Date: 17 January 2025
Our ref: 497689
Your ref: **EN010128**

NSIP Reference: EN010128

**The Examining Authority's first written questions and requests for information (ExQ1).
Examining Authority's submission deadline: 17 January 2025**

Annex 1: Natural England’s response to the Examining Authority’s (ExA’s) first written questions reference ExQ1

Figure 4-1 – Indicative Site Layout Calculated Lux Levels

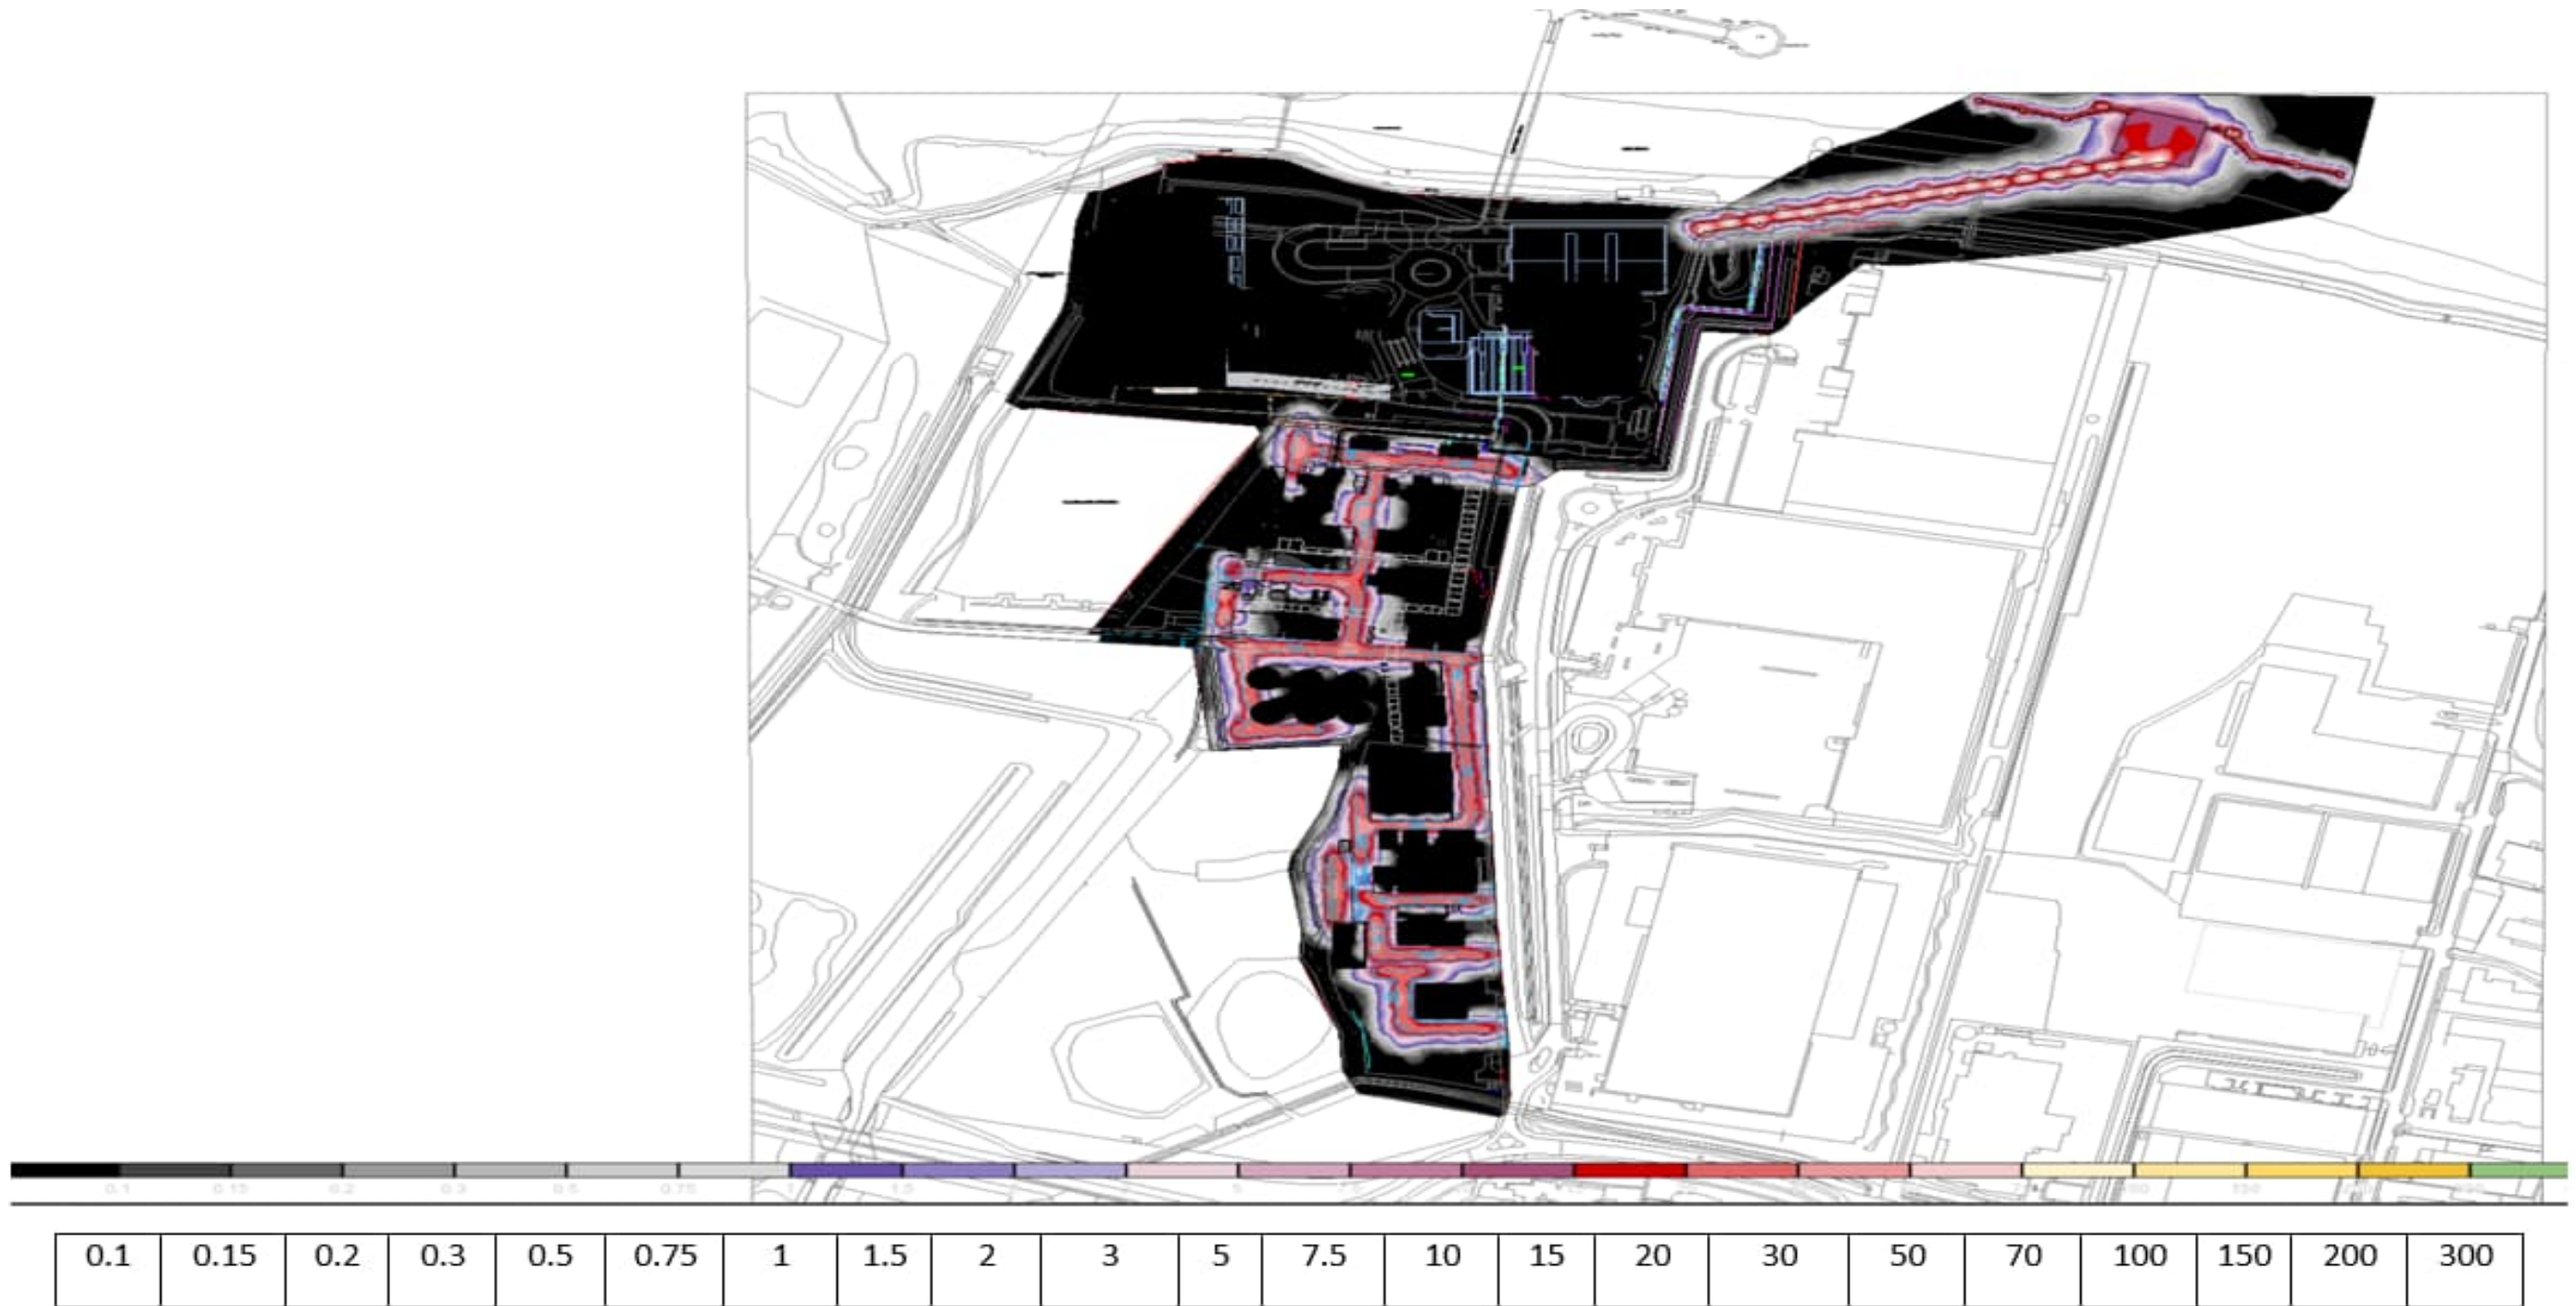
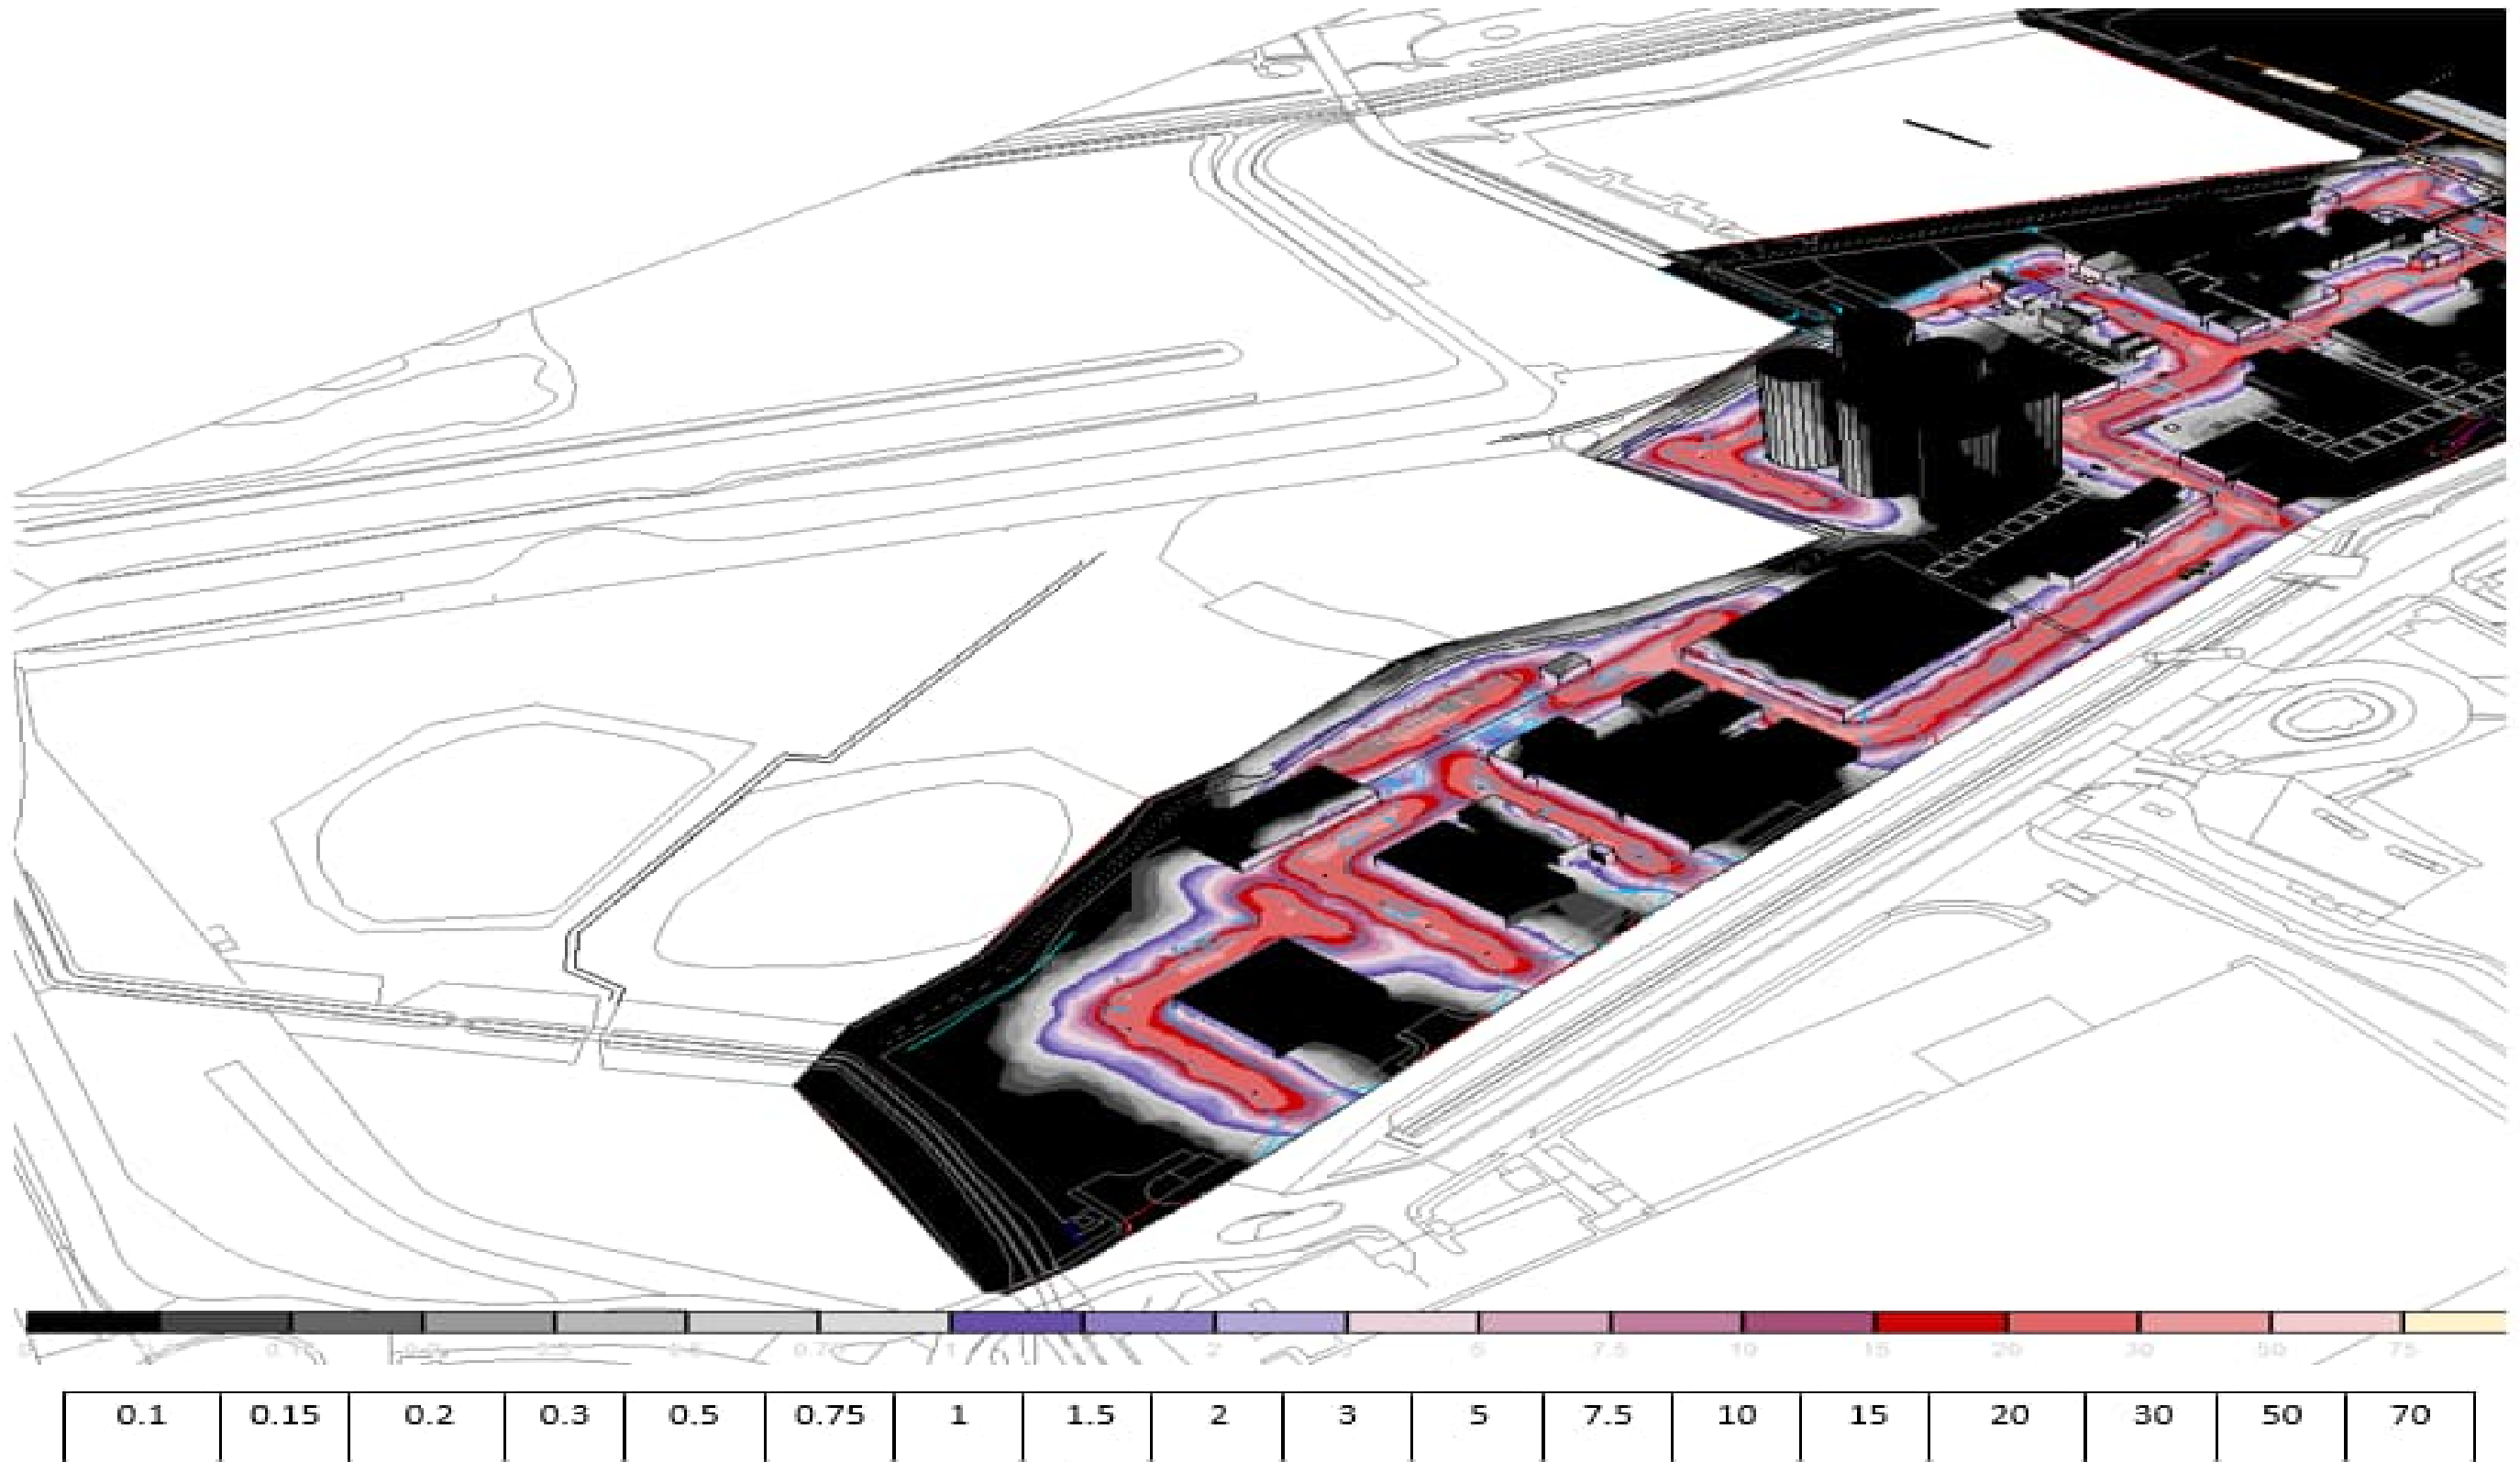
Q 1.3.1.5	The Applicant, NE and EA	<p><i>Would the lighting strategy required by Requirement (R) 11 in the dDCO be capable of mitigating effects of lighting on water voles? If so, please provide a full and detailed justification and if not, what alternative arrangements are proposed?</i></p> <p>The effects of lighting were not discussed as an impact to water voles within the Method Statement that Natural England reviewed. The lighting strategy [APP-123] does not specifically address potential impacts to water voles, or the mitigation of any impacts. Natural England has advised the Applicant that this section should be revised within the re-submitted version in order to ensure all the impacts of the proposed development are considered.</p>

ExQ1	Question to:	Question and Answer:
		<p>In principle, yes. We advise that we believe the wording of R 11 [REP1-002] as proposed, should be capable of ensuring any impacts to water voles are avoided or mitigated. The effectiveness of the requirement relies upon the detail and content of the lighting strategy [APP-123]. As discussed above, the lighting strategy [APP-123] does not currently specifically address potential impacts to water voles, or the mitigation of any impacts.</p> <p>Natural England would be pleased to be consulted on updates to the lighting strategy.</p>
